City Park Development at the Former Tedcastles Site

Quality Audit

Reference: 267365-ARUP-XX-XX-RP-YT-0015

City Park Development at the Former Tedcastles Site, Centre Park Road, Cork

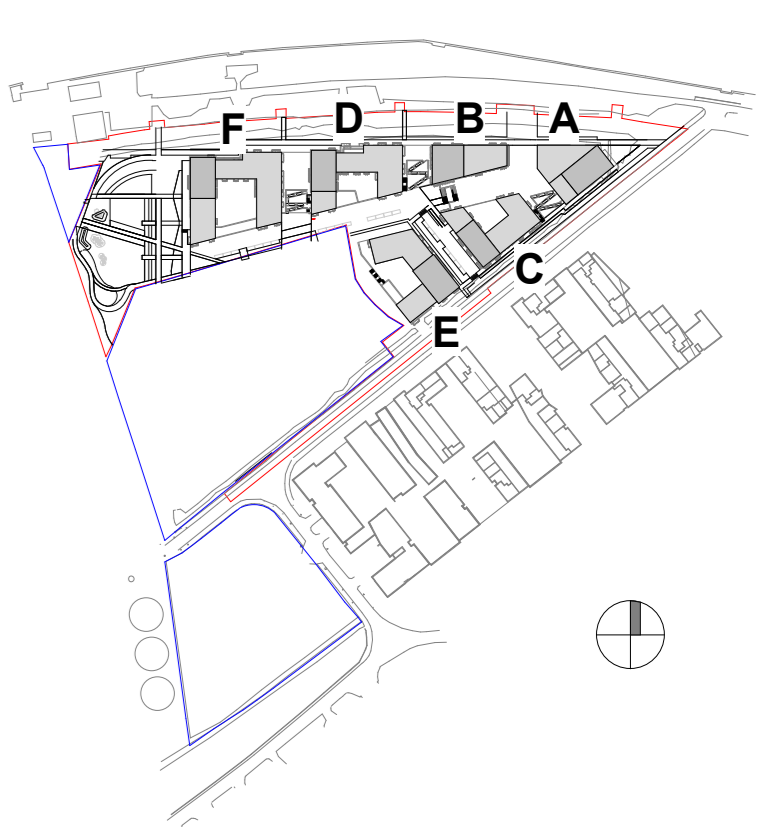
There is a danger that a motorist, unfamiliar with the carpark layout, entering the carpark may not appreciate the one-way system, especially if the white arrow road markings are obscured by an oncoming vehicle.

Motorists might not be able to see if there are any vacant spaces along a long aisle in the carpark which could lead to motorists requiring to turn around within the aisle.

Many of the end parking bays may be difficult to use requiring multiple reversing movements.

At a few locations, a parked car may block a doorway leading to the risk of trapping a person inside. Some doors appear to open out into the aisle where they could be struck by a passing vehicle.

It is not proposed to provide any advisory lanes to guide pedestrians safety to the nearest exit.

The Marina amenity will be a desire line (and vice versa) for many pedestrians and cyclists from the development. The proposals include a series of connections into the car park from the development which appear to be blocked by parking spaces.

Recommendation 2.10: Appropriate road markings should be provided. White arrow markings should be frequent and supplemented by other road markings such as a guidelines, text markings and signage to ensure one-way system is clear.

Recommendation 2.11: The last four spaces should be removed to provide a link between the two adjacent aisles allowing vehicle to circulate more freely.

Designers Response: Yes | Yes | A suitable turning space will be provided for vehicles.

Recommendation 2.12: A vehicle sweep assessment should be carried out to ensure that motorists driving a large car can safely and easily use all end parking spaces when all of the adjacent spaces are occupied.

Recommendation 2.13: All parking spaces should be kept clear of doorways and escape routes. Ensure that door cannot open in front of a car travel along the aisle.

Recommendation 2.14: Provide road markings advising pedestrians of the safest areas to cross aisles and along with signage, the most direct and safest route to the exit points. If aisle widths are restrictive, then these need only to be advisory allow vehicles to drive on them if needs be.

Recommendation 2.15: Appropriate crossing facilities should be provided through the car park between the proposed development and the greenway, giving priority to vulnerable road users.
